Our Ref: A/85/18/RES
Your Ref:

Application for Approval of Reserved Matters Following Outline Approval

Development Approval of reserved matters for appearance, landscaping, layout & scale following outline consent A/131/16/OUT for 9 No one & a half storey houses with garaging, including 3 No. affordable housing units.

Location Land between New Place Bungalow and Arundel Road Angmering

ELEVATIONS: combined
UNITS: 4 + 5

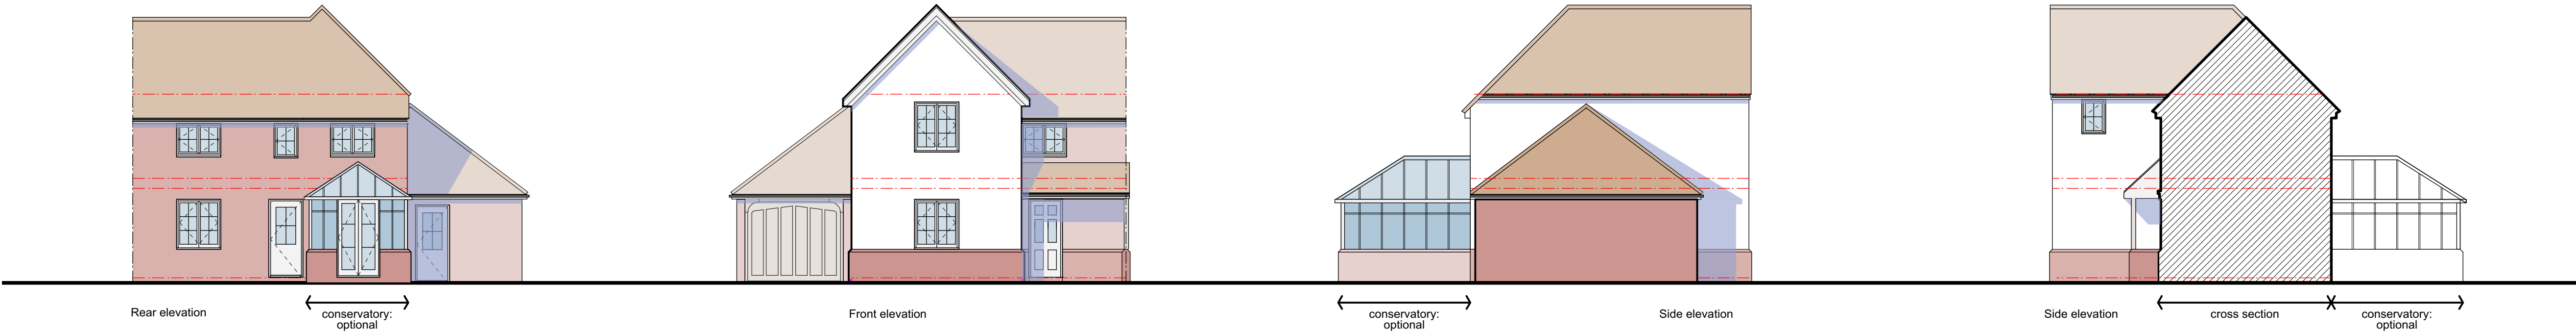
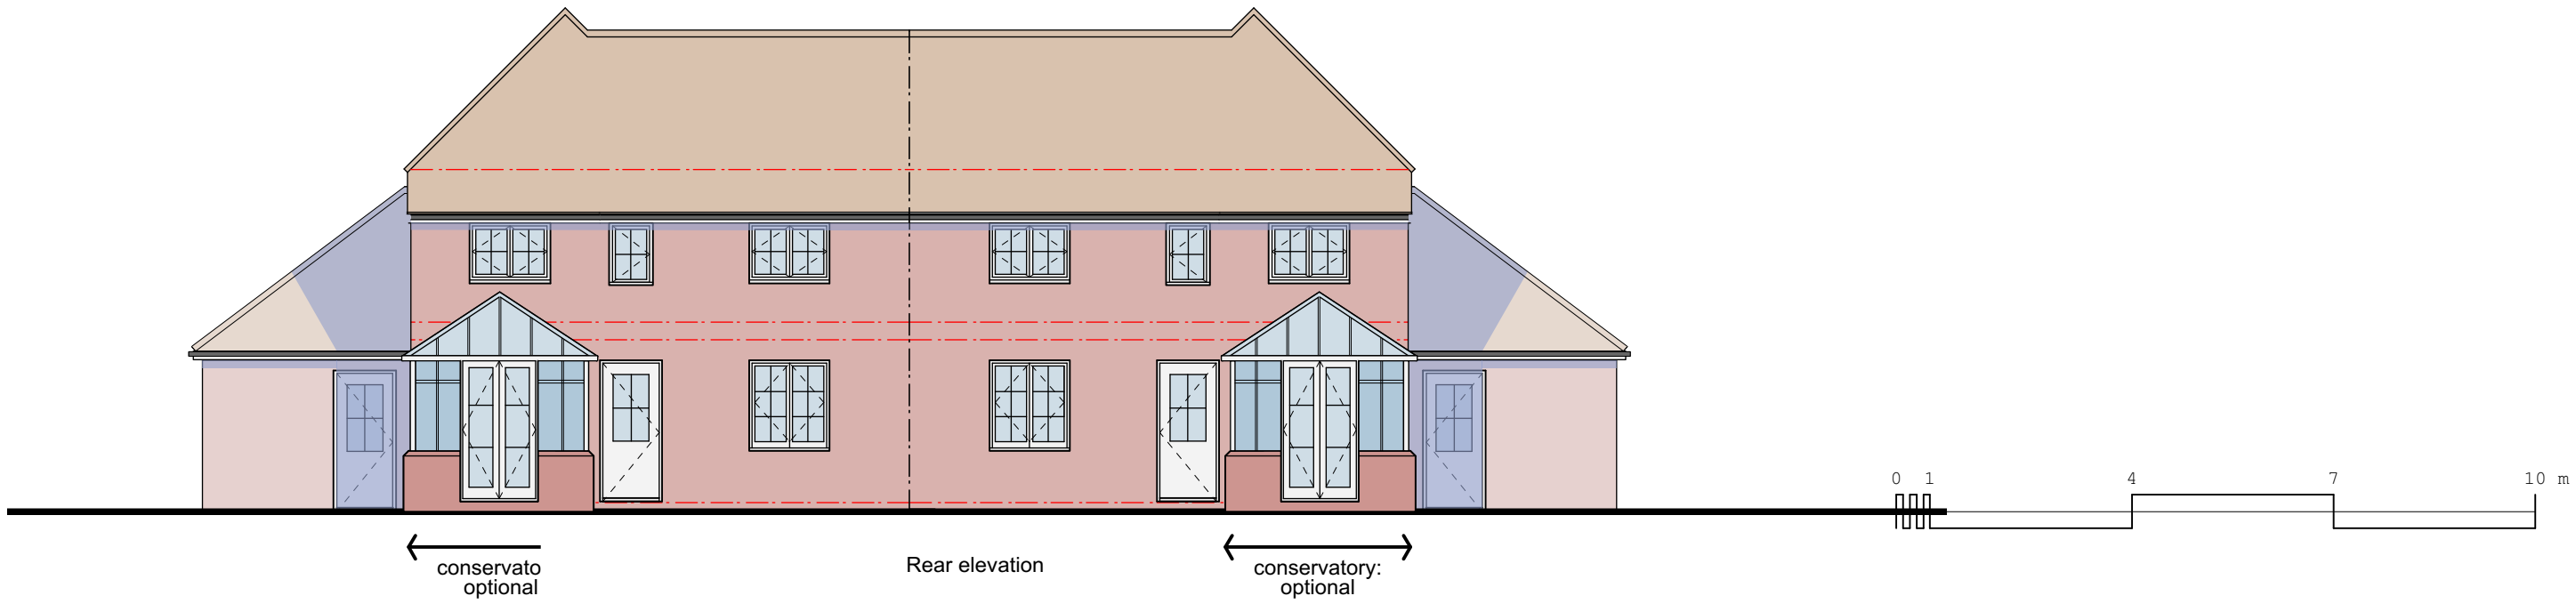
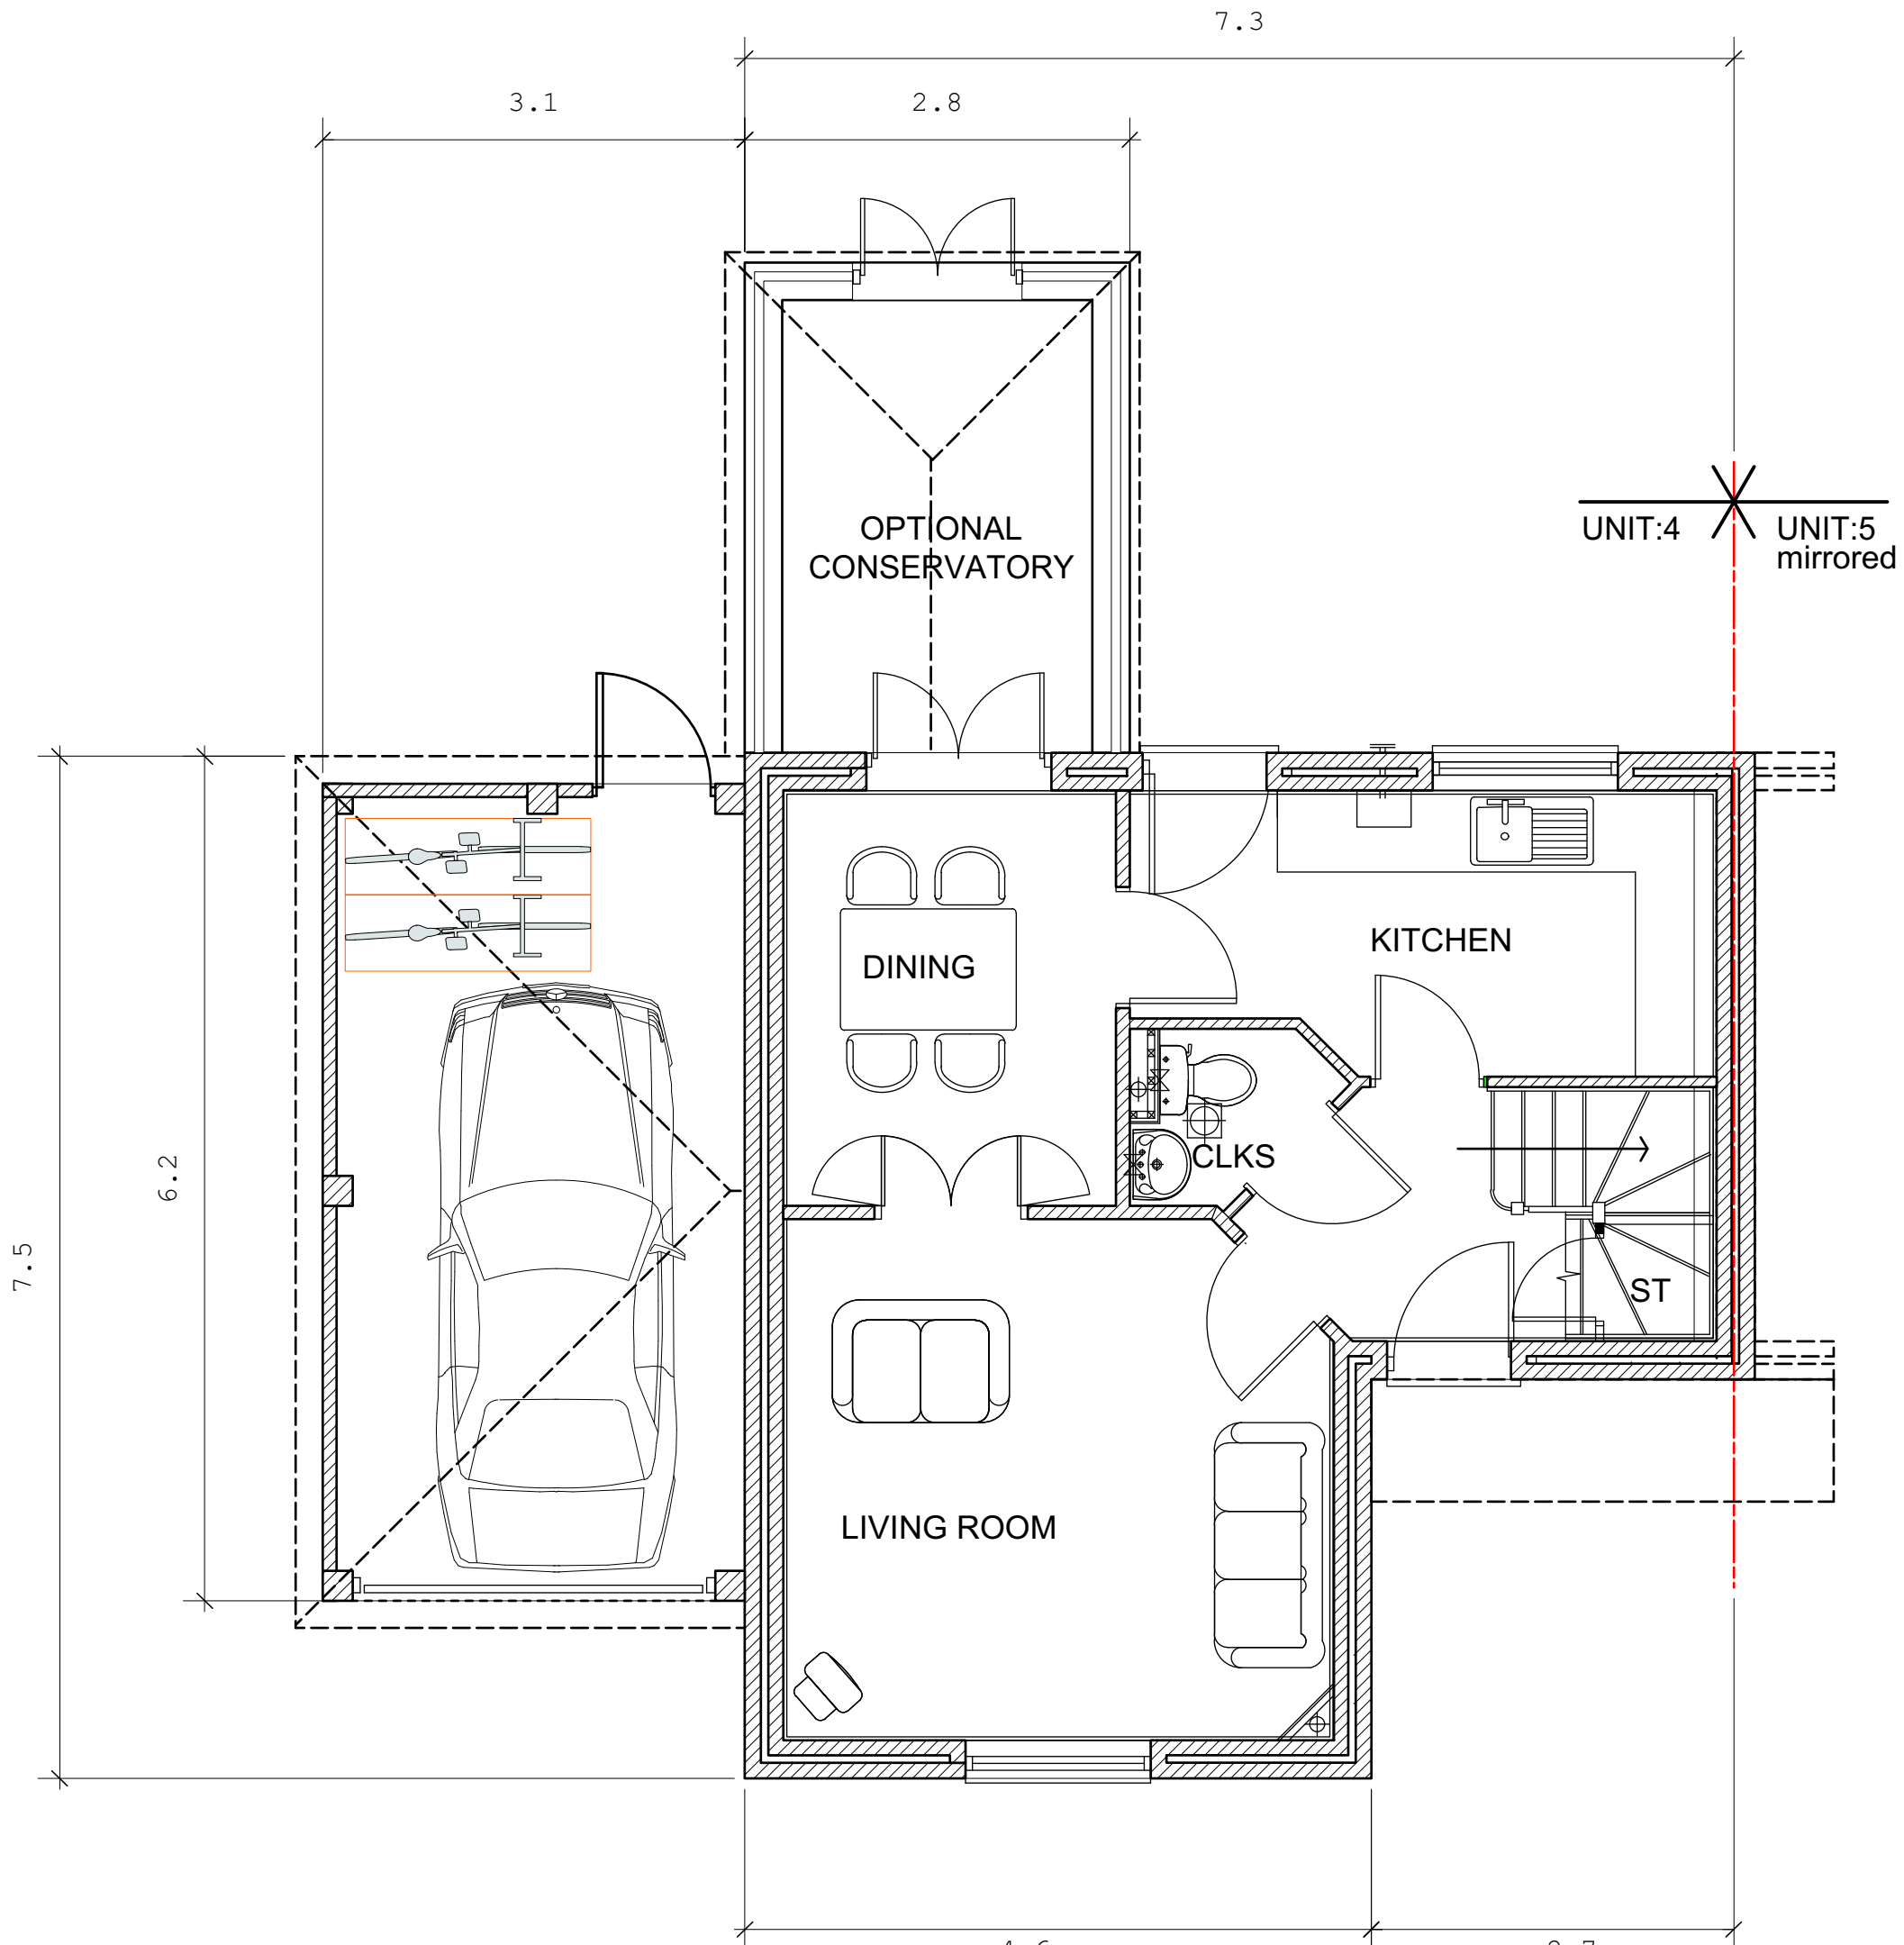
The plans, Unit B & C, rear elevation and ground floor plans do not accord. Please amend accordingly.

The plan, Unit D shows elevations for plot 4 and does not match the other plot 4, on plan Unit C. Please amend accordingly.
